From: Carol Reynolds
Sent: 09 January 2019 15:32
To: Planning.Responses
Cc: Anita Gardner; 'Bob Bevan'; 'Kevin Conlon'
Subject: FW: Yeomans Honda Discharge of Conditions - External Lighting Ref FG/171/18/DOC

Environmental Health: Agree to discharge of Conditions 9 and 14 on the basis of application of changes agreed as below.

Subject: Yeomans Honda Discharge of Conditions - External Lighting Ref FG/171/18/DOC

DRAWING TITLE
Proposed external lighting scheme

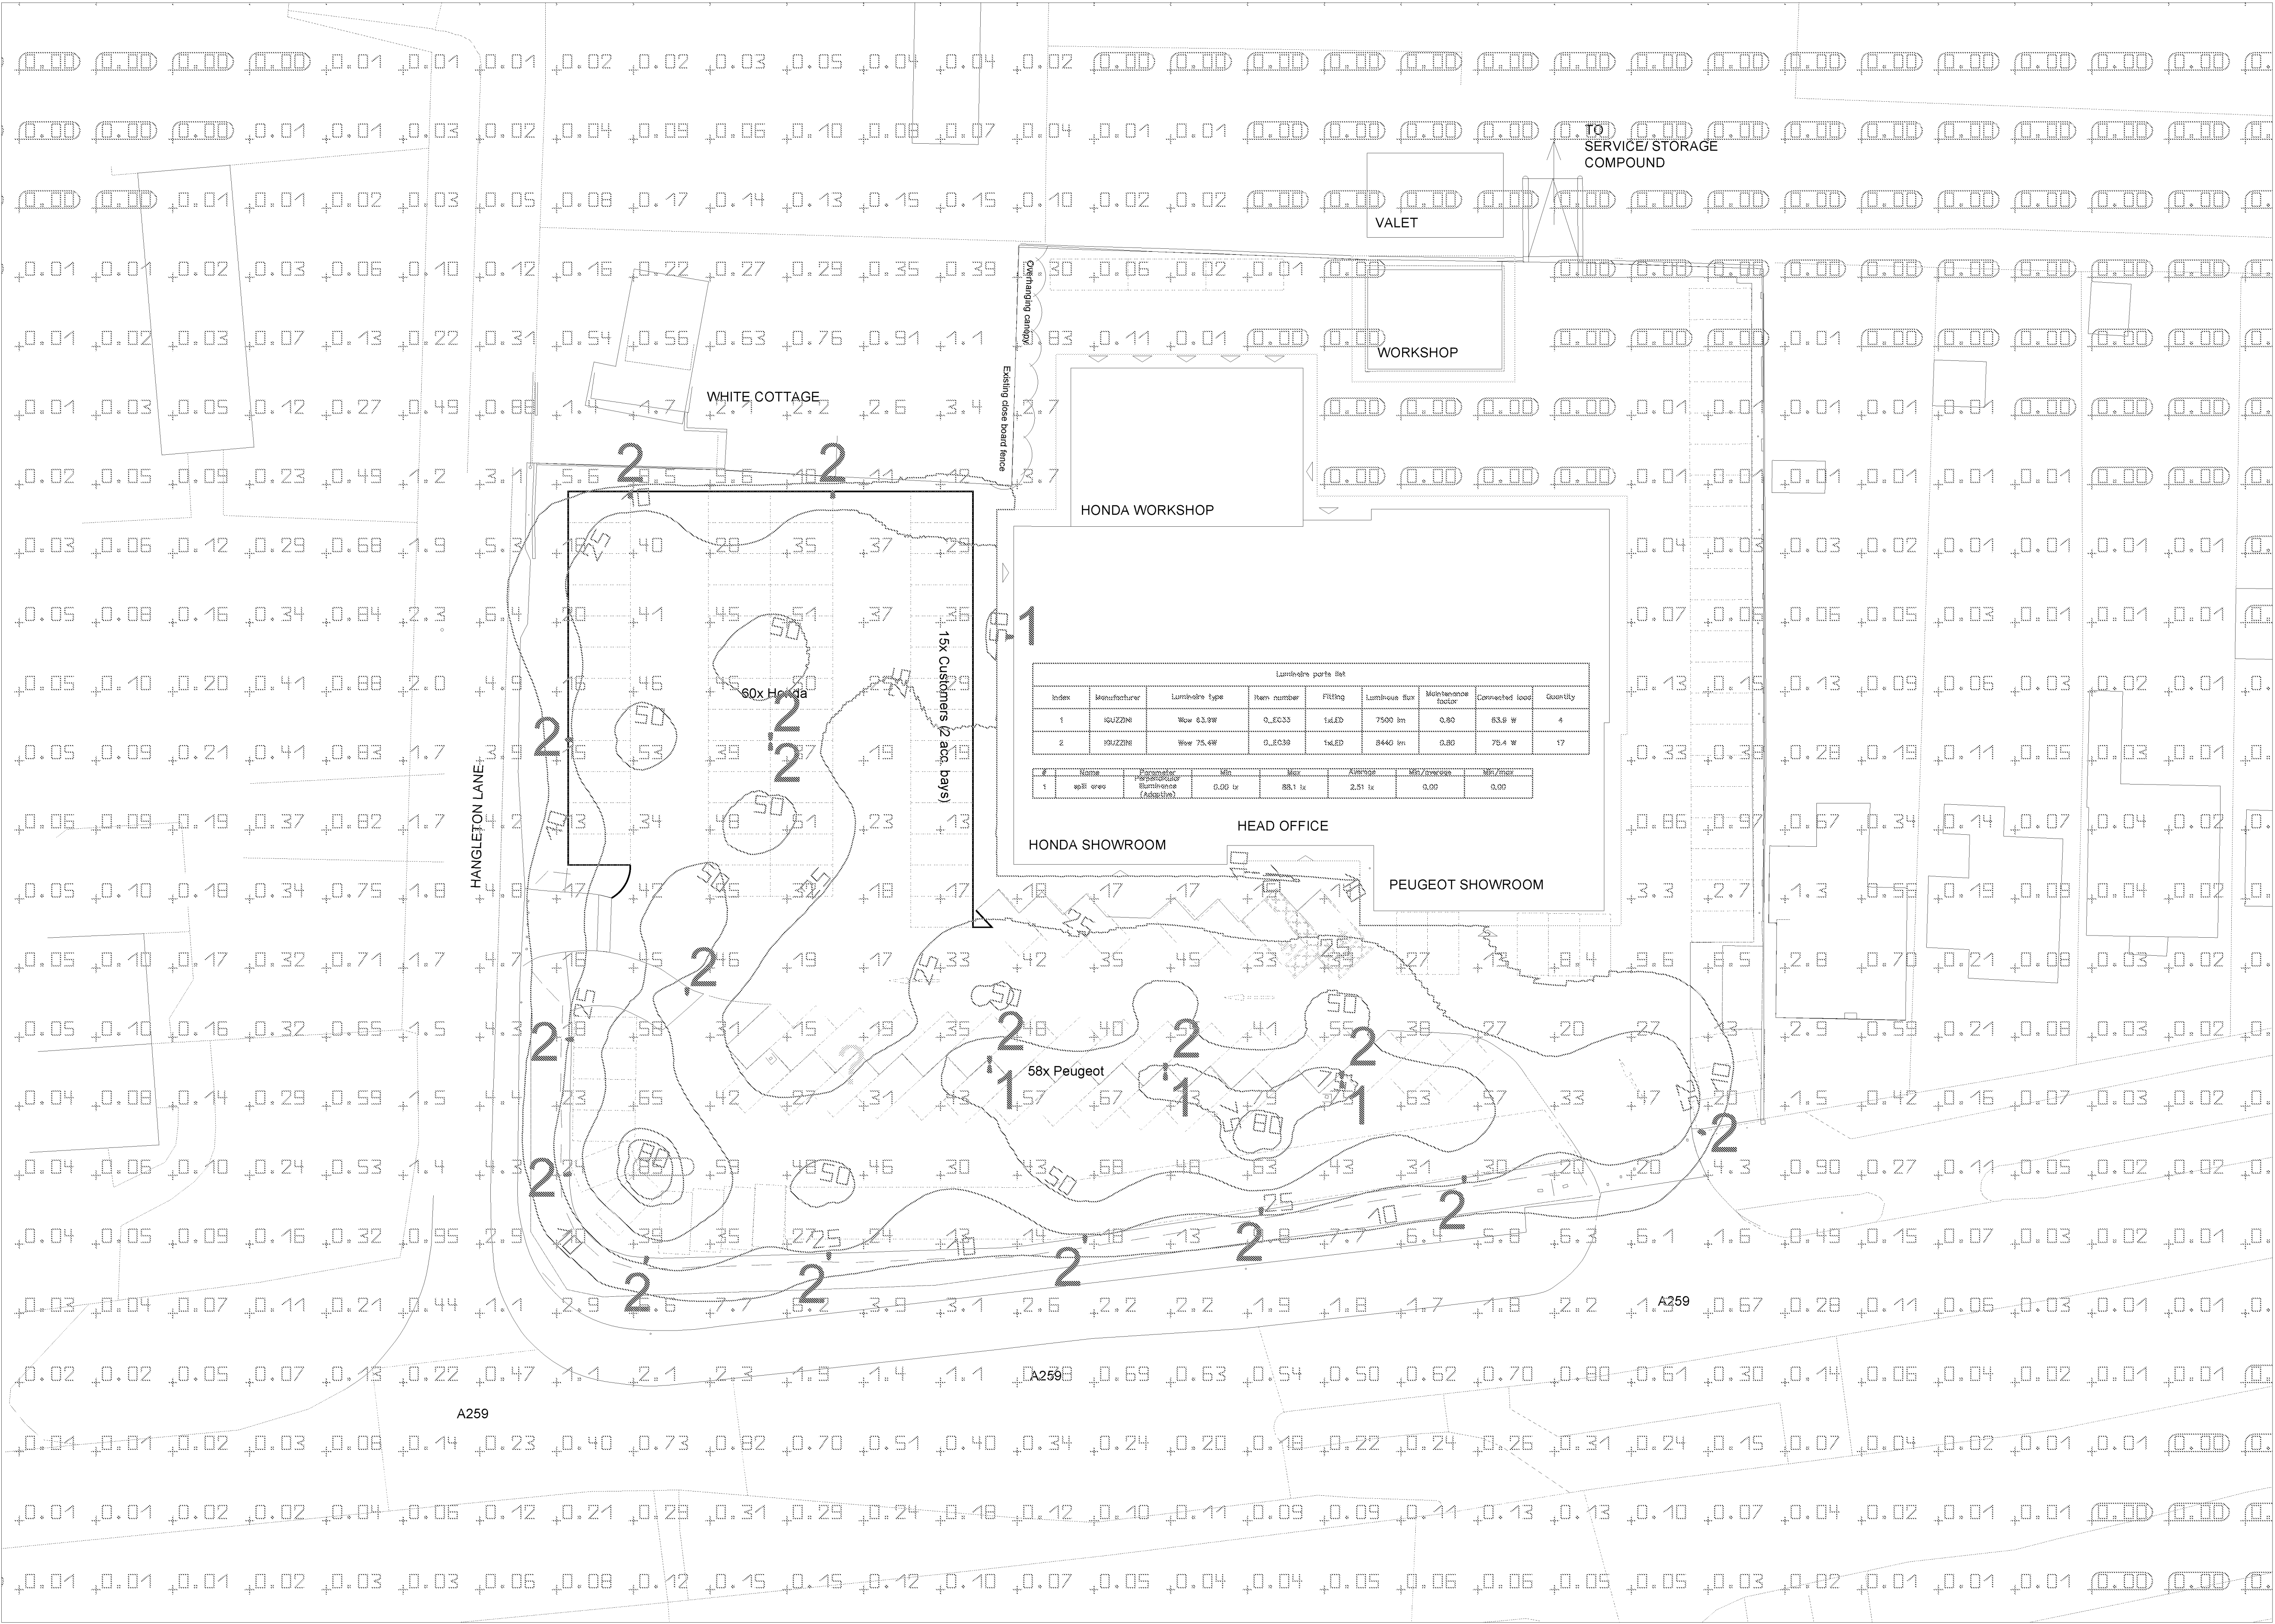
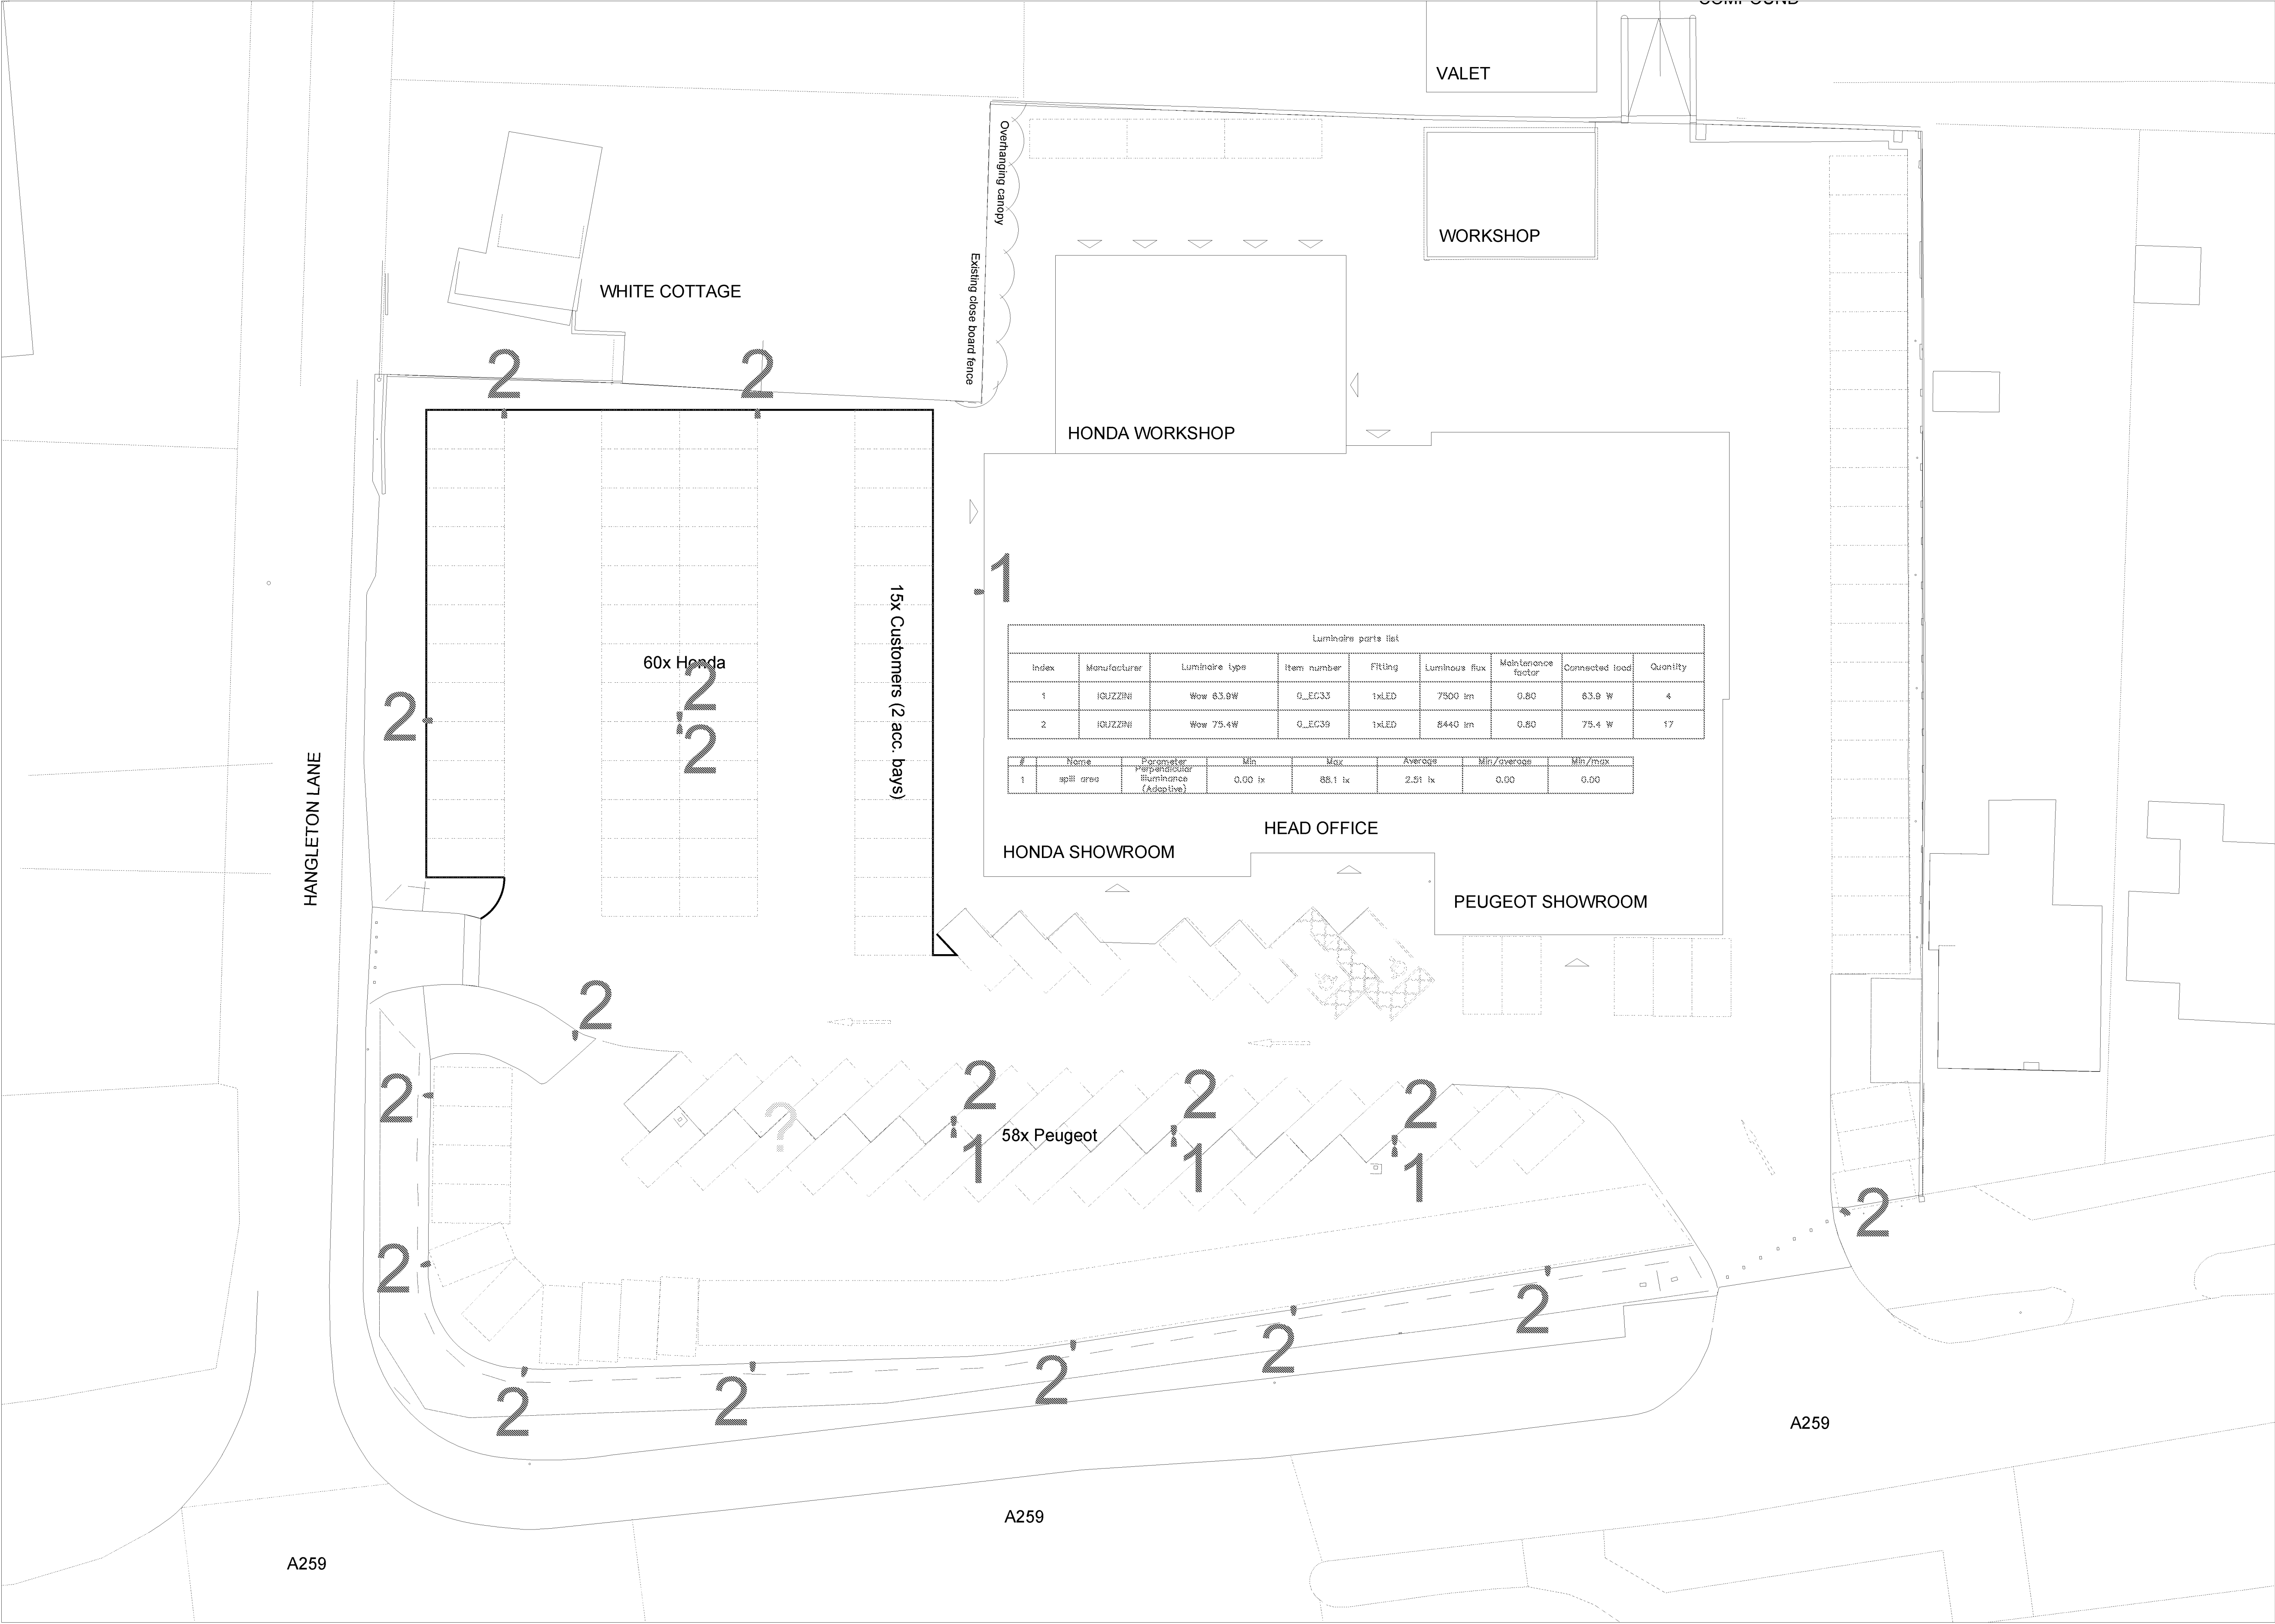
Thank you for your clarification as below, with which I concur with the exception that lighting provided on any Sunday, or Bank holiday should be switched off after the latest hour of operation for this site ie 18:00 hours.

1. Angled ref. 2 fittings on 'white cottage' boundary a further 5° to 10° to reduce back-spill and potential view of light source You are happy with this statement.

2. Moved new wall-mounted fitting further 'down' (looking at plan) from 'white cottage' boundary to reduce spill and move product further away from being seen You are happy with this statement.

3. Angled ref. 2 fitting on new double-head column which faces toward 'white cottage' boundary -5° to reduce spill. This statement has been amended following our conversation.

4. Instead of altering fitting selection or column heights, I'm suggesting fittings marked '*' could be dimmed to 50% [post-curfew?] using astro timer etc. with additional switched live provided to product as per installation instructions. The new car park lighting will reduce to 50% lux level between 18.00 hrs and 19.00hrs and at 19.00 hours the lighting to the new Car Park will be switched off via time clock.

New lighting plot attached shows this situation with '*' fittings dimmed to 50%. I have shown additional detail including 1 lx boundary which does fall beyond site extent however appears to stop short of actual neighbouring property. After this boundary, spill is more-or-less negligible, especially considering calculation does not include soft/hard landscaping present which would attenuate lighting beyond site even further.

Please see Tables 1 & 2 below – using “Zone 2 Rural Surroundings for this area” rather than “Zone 3 Suburban” this suggest a limit of 5 lux pre-curfew and 1 lux post-curfew. The calculation shows that whilst the 1 lux boundary of back light/spill light does extend slightly beyond the site boundary, it does not actually reach the neighbouring property and therefore will be comfortably below the post-curfew limit for light intrusion into windows as per Table 2.

We confirm that the external lighting to the new Car Park area on a Sunday and Bank Holiday will be switched off at 18.00hrs.
